**C. Christian Berg, PE**

February 6, 2020

Re: Lot 1 – 2434 Neills Creek Road  
Lillington, NC

At your request, I have reviewed the plans proposed for new construction at this address. These plans were purchased from Frank Betz Associates and are entitled "The Foxcrofte". The architectural plans are dated 8/9/02, and the structural plans are dated 5/12/03. I reviewed the following sheets:

1 CORNICE DETAIL  
3/4" = 1'-0"

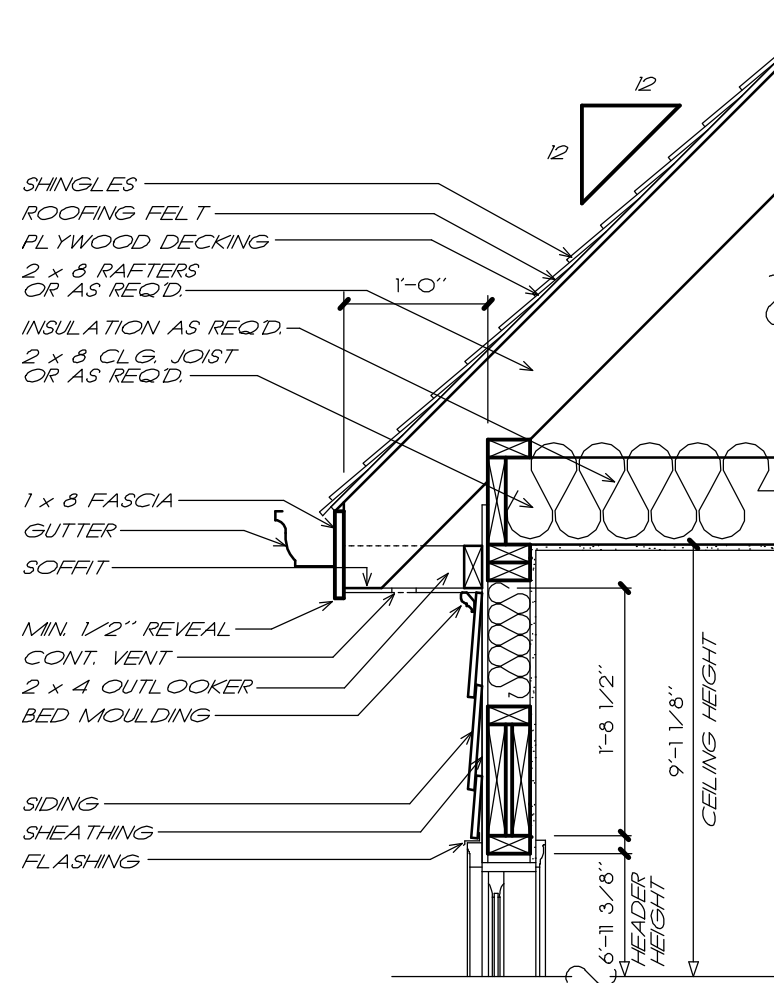
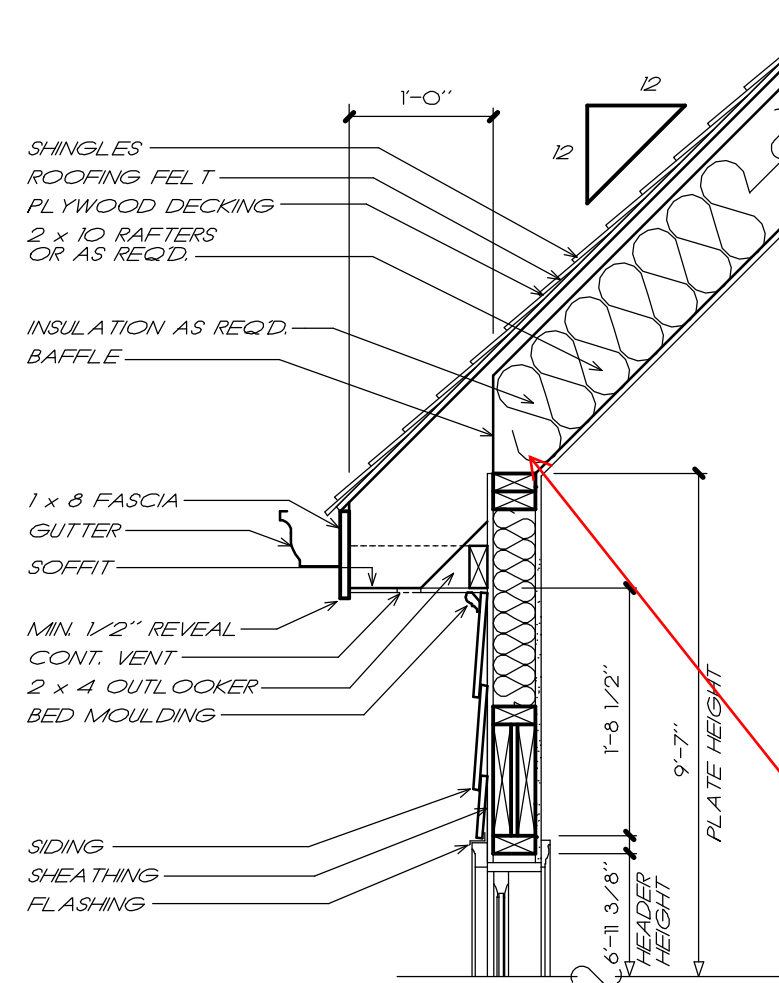
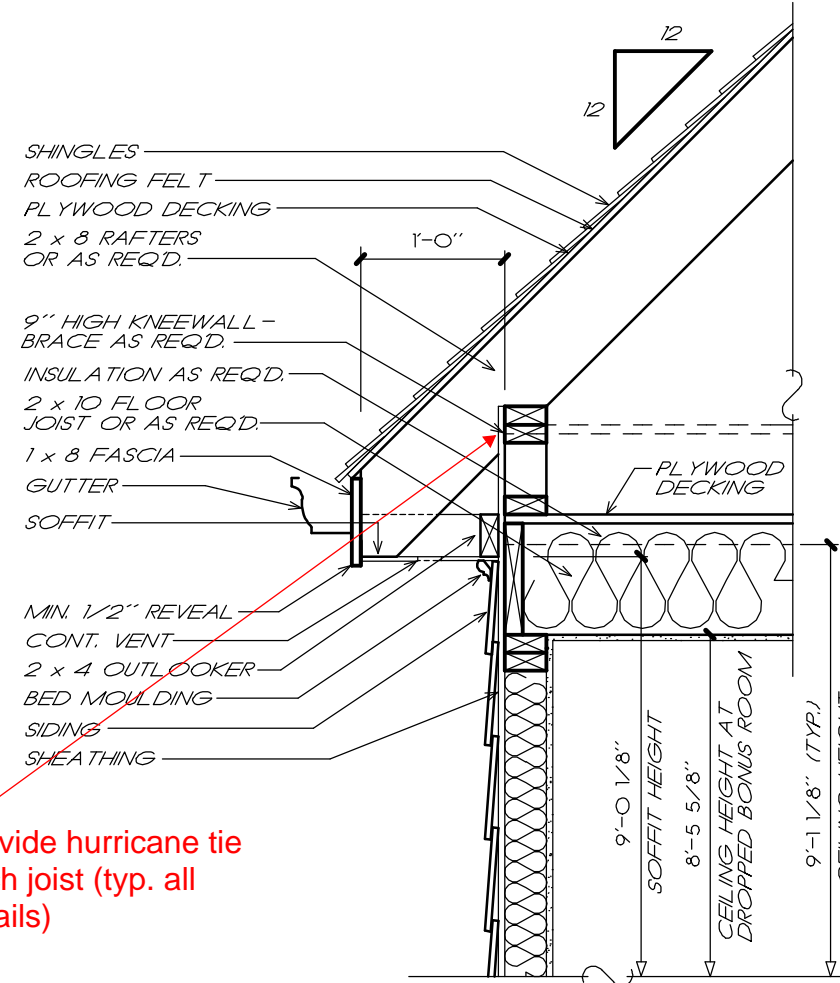
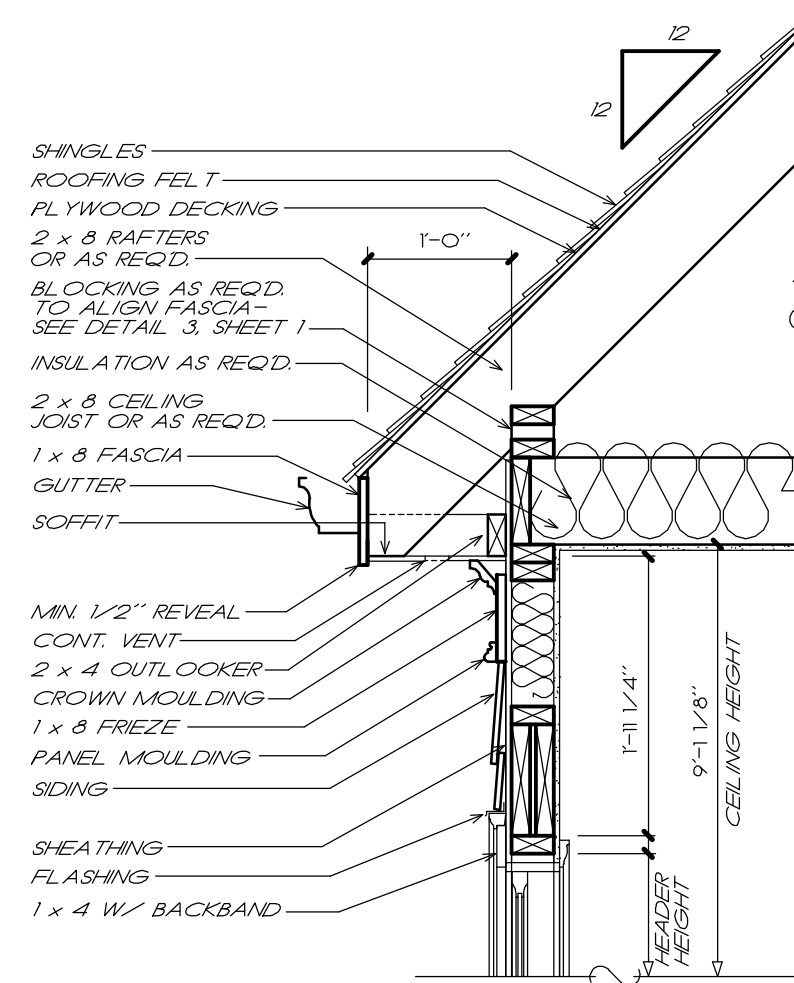
Provide hurricane tie  
each joist (typ. all  
details)

**CRAWL FOUNDATION PLAN**

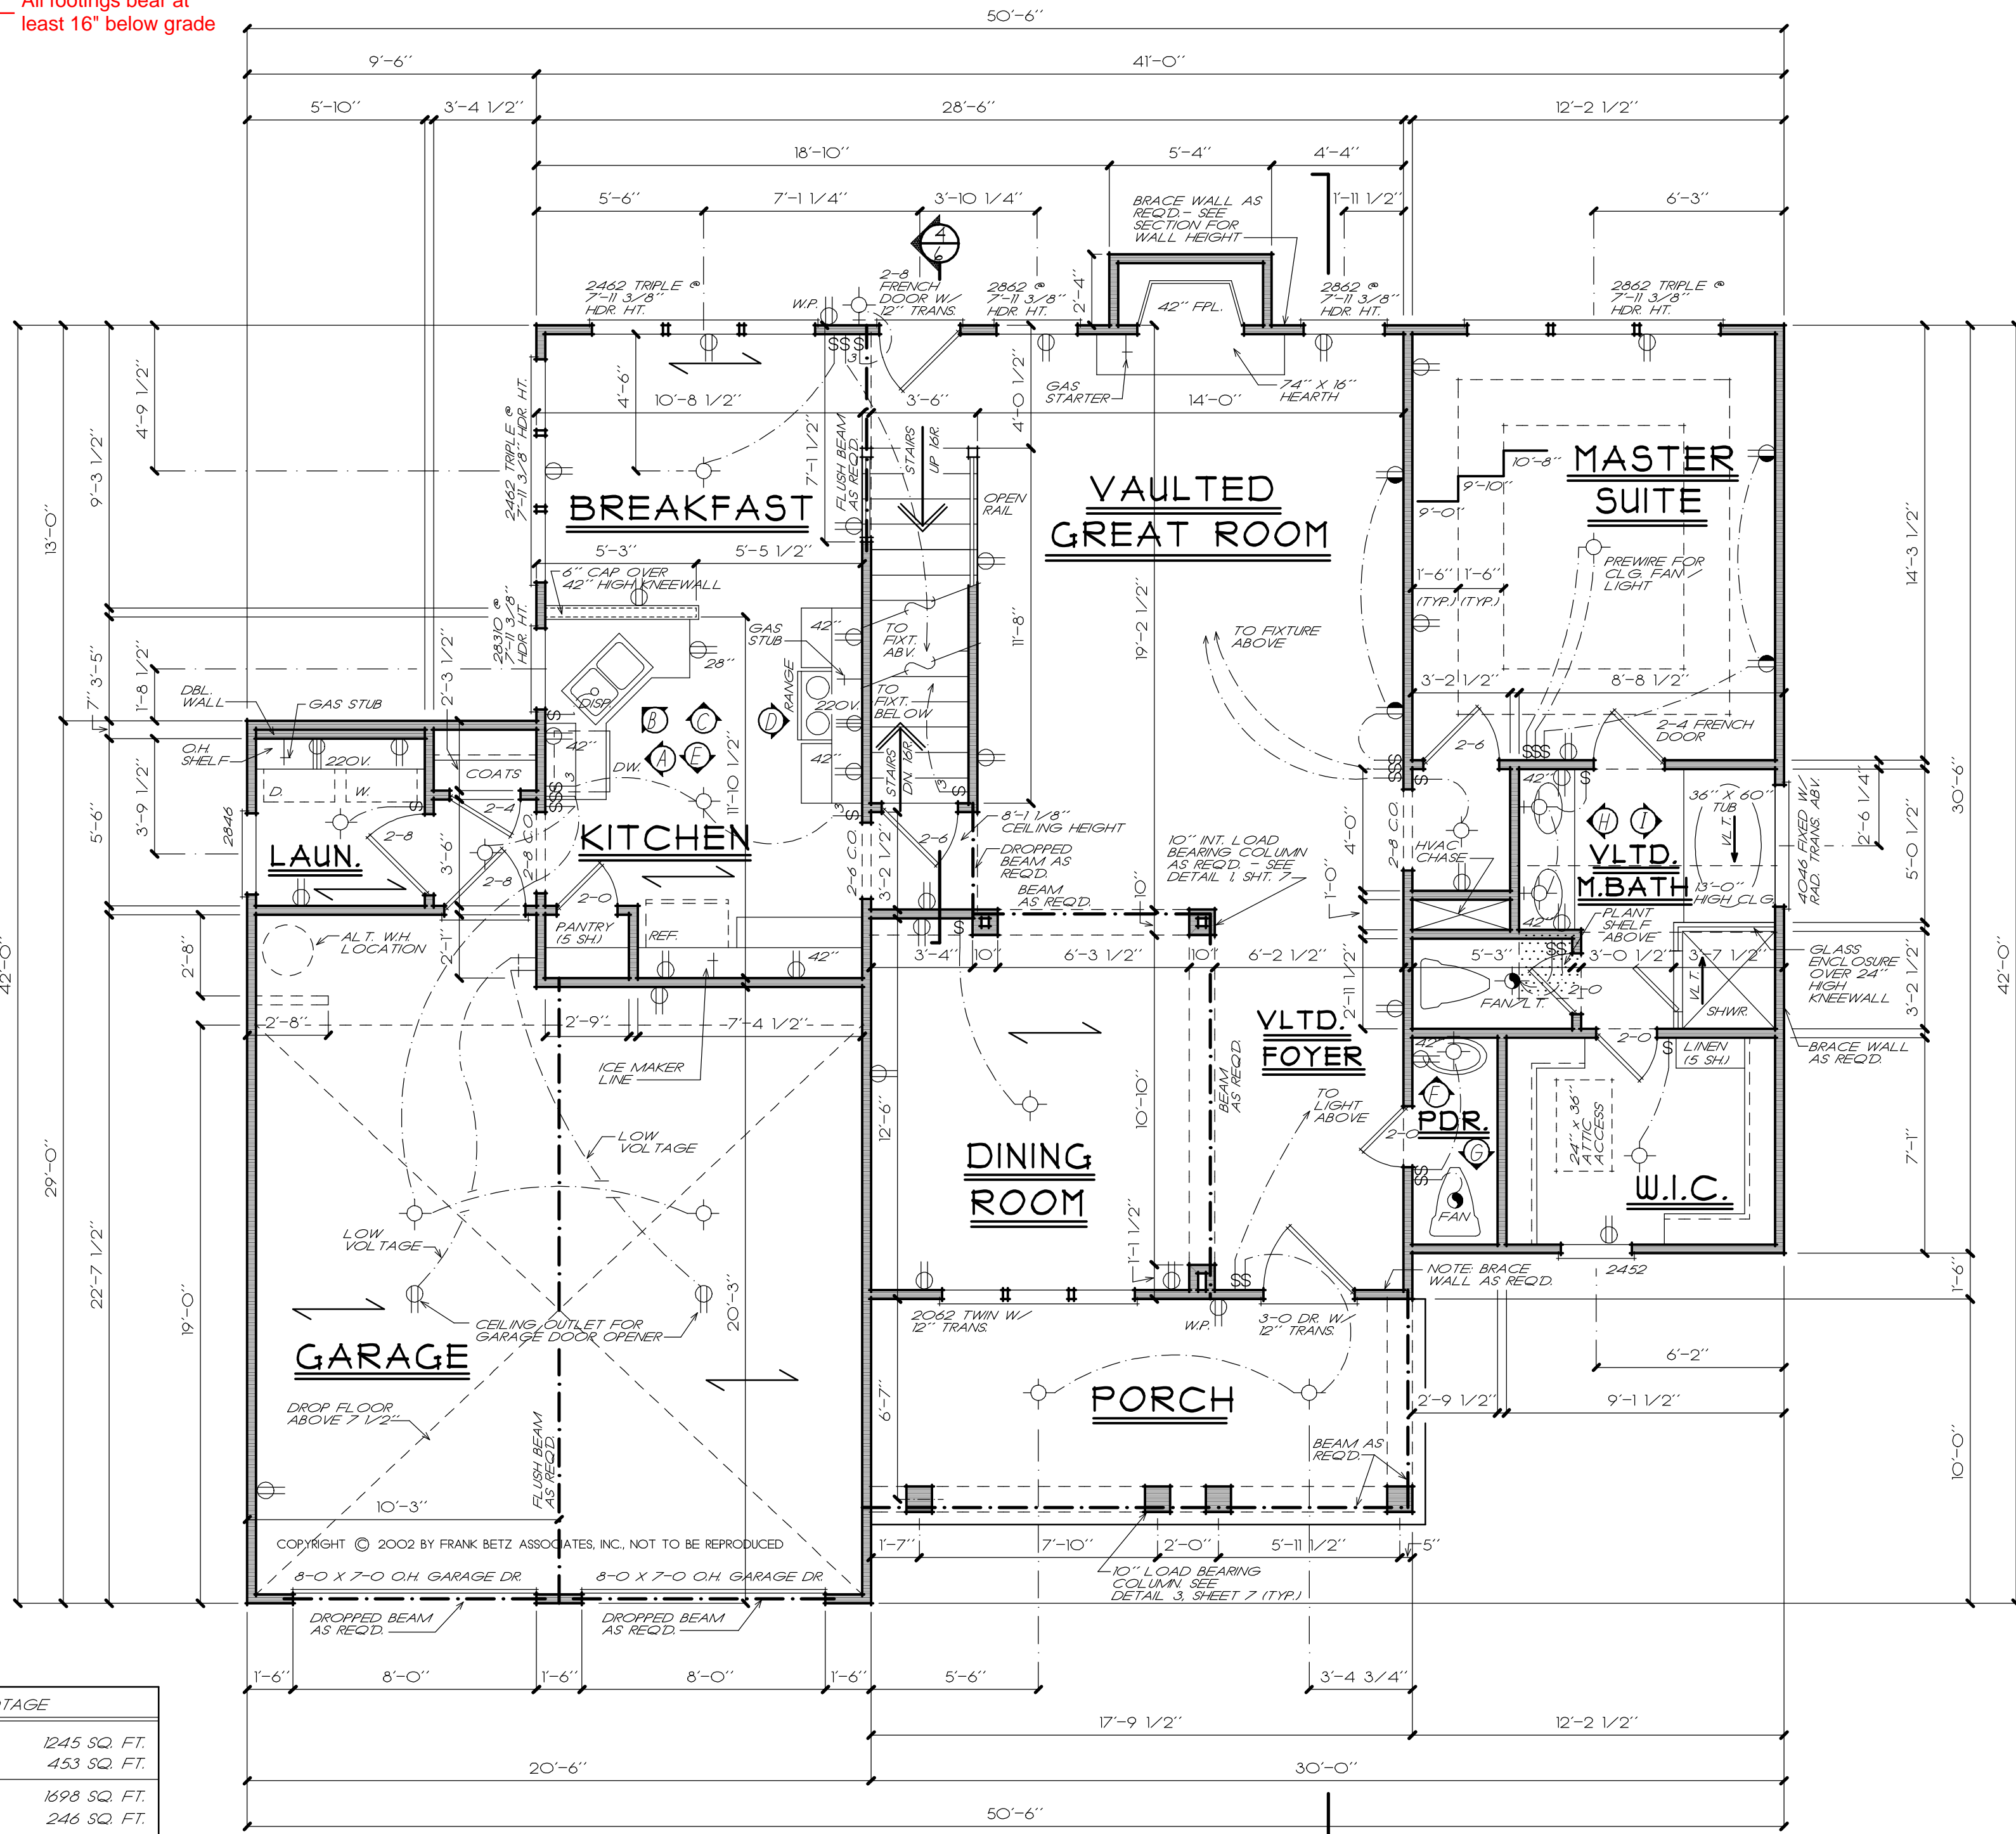
**Foundation Vent Calculation**

Crawlspace Area = 1,143 SF

Req'd Vent Area =  $1143/150 = 7.62$  SF

Each 8"x16" vent is .85 SF

Vents Req'd =  $7.62/.85 = 8.96$  - provide 9 min.

**SECOND FLOOR FRAMING PLAN**  
 1/4" = 1'-0"

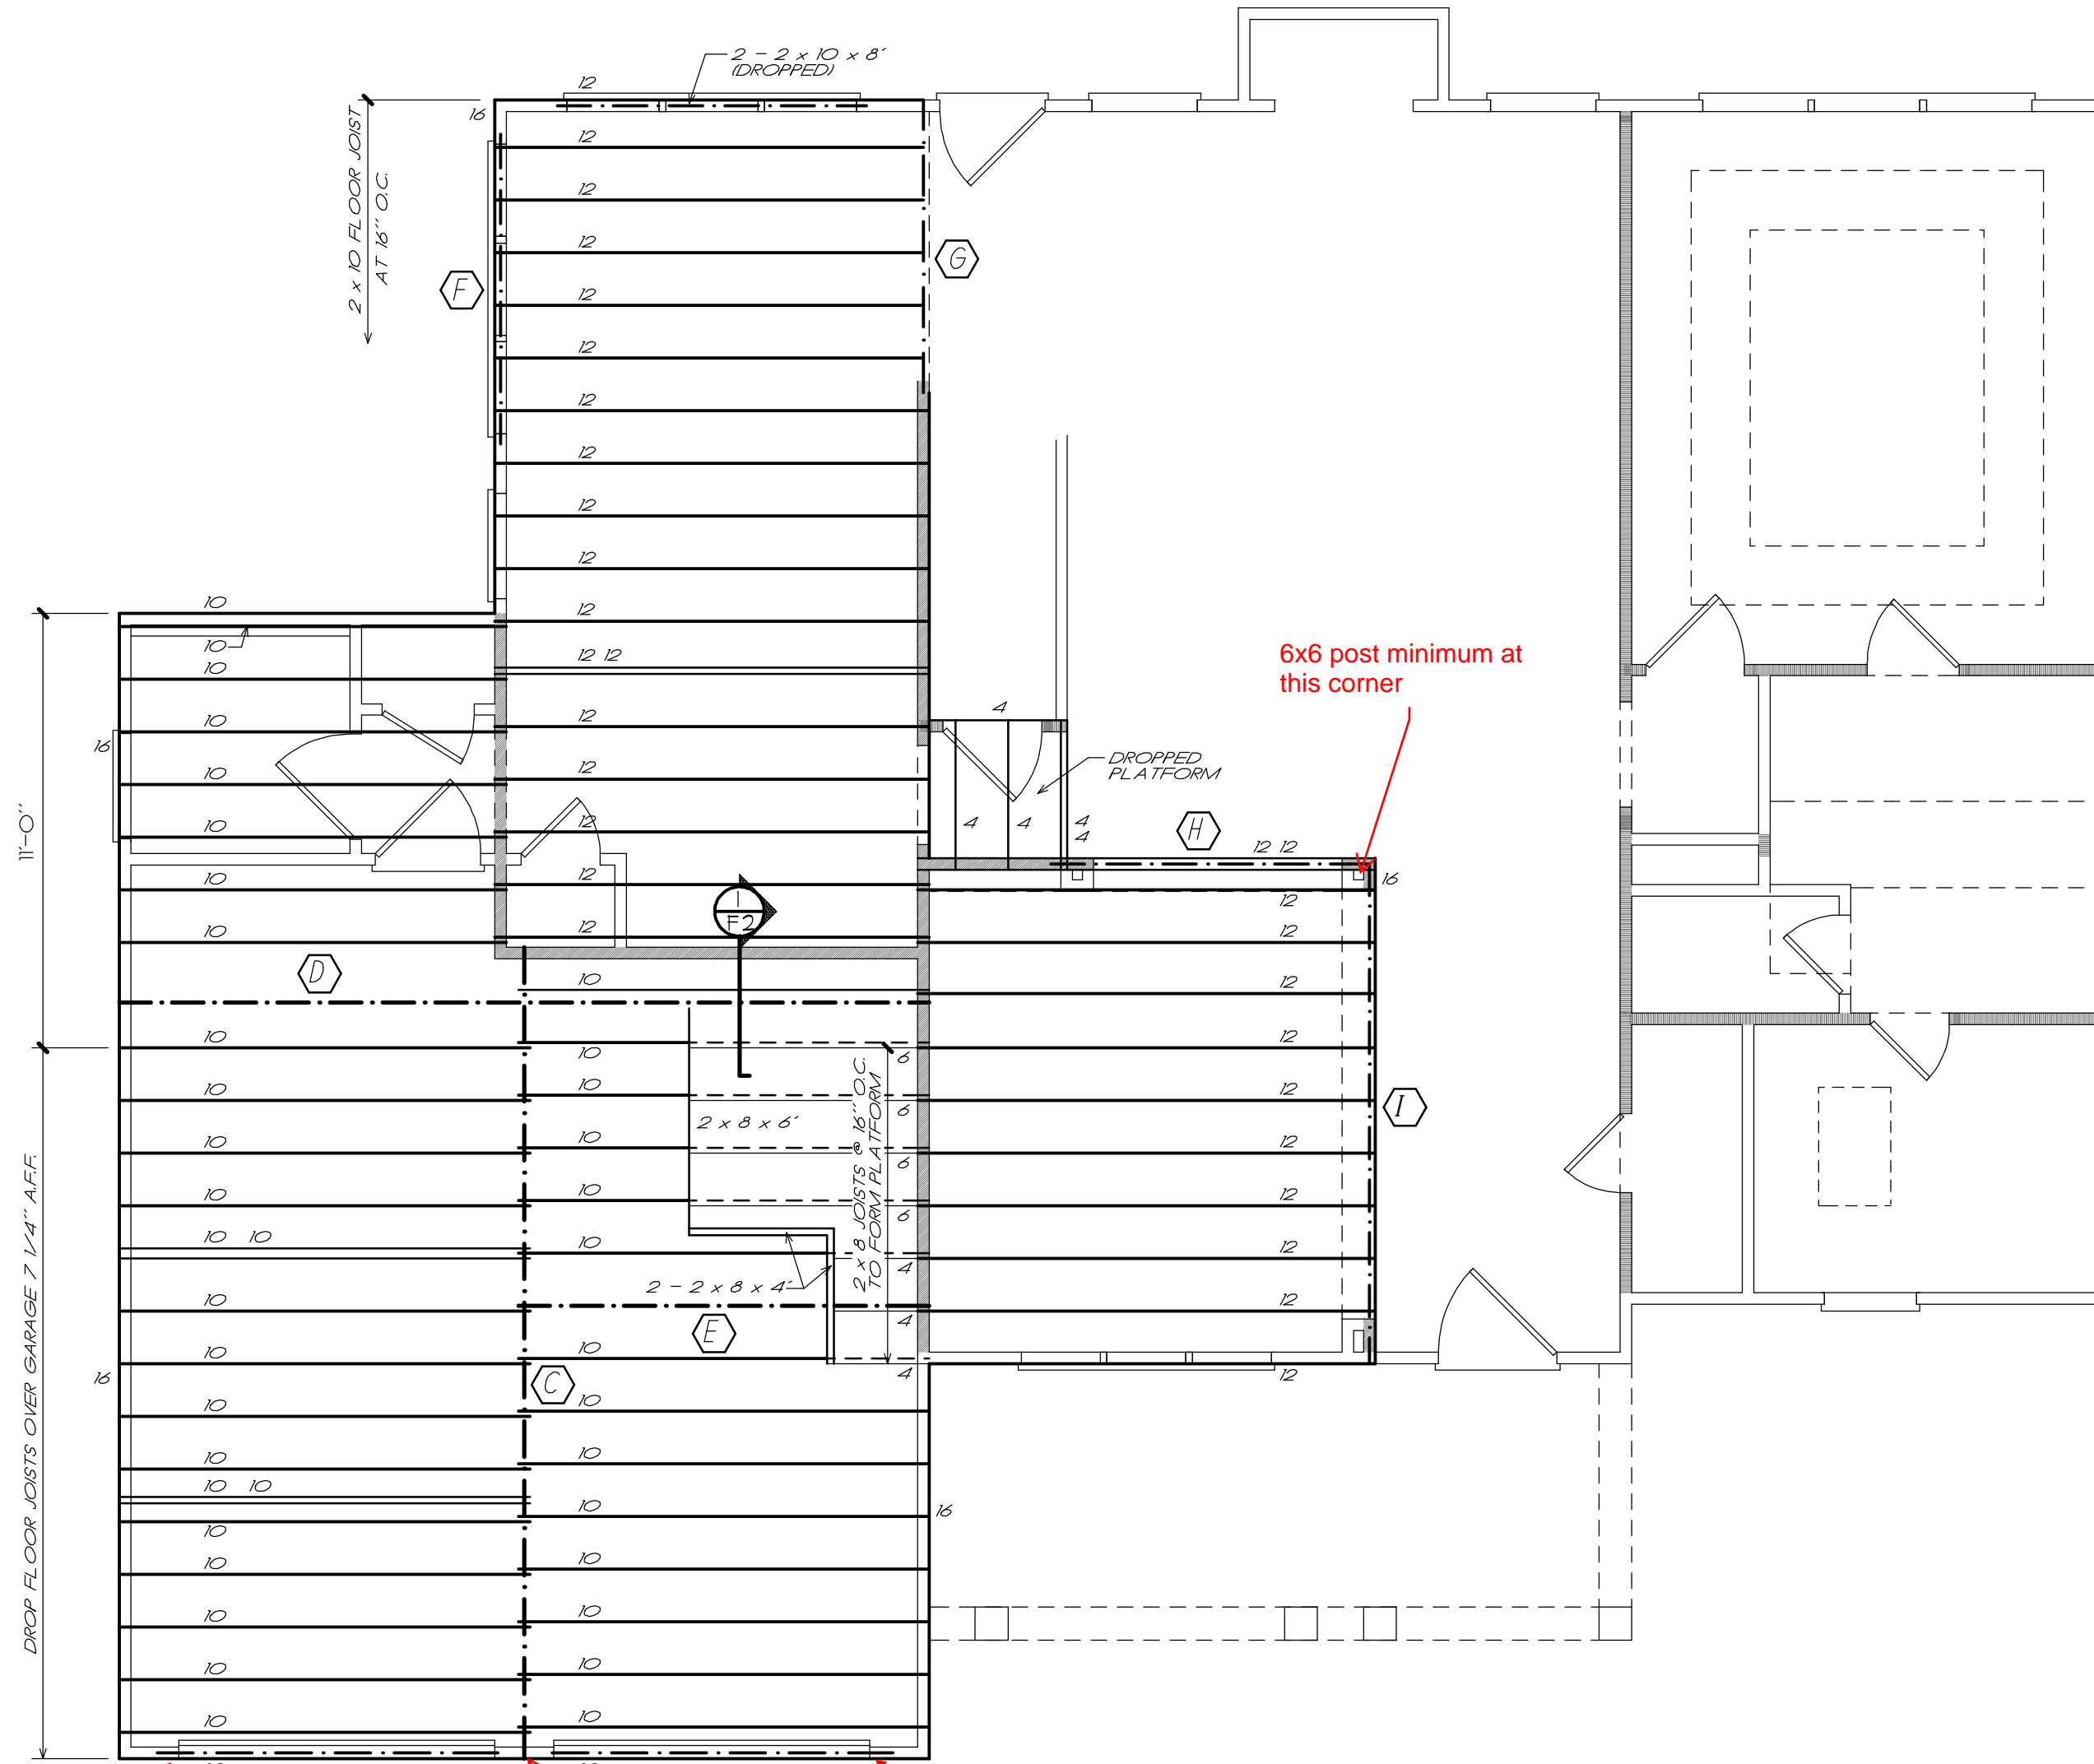
this wall and headers constructed as portal frame per figure R602.10.1 in NC Residential Code
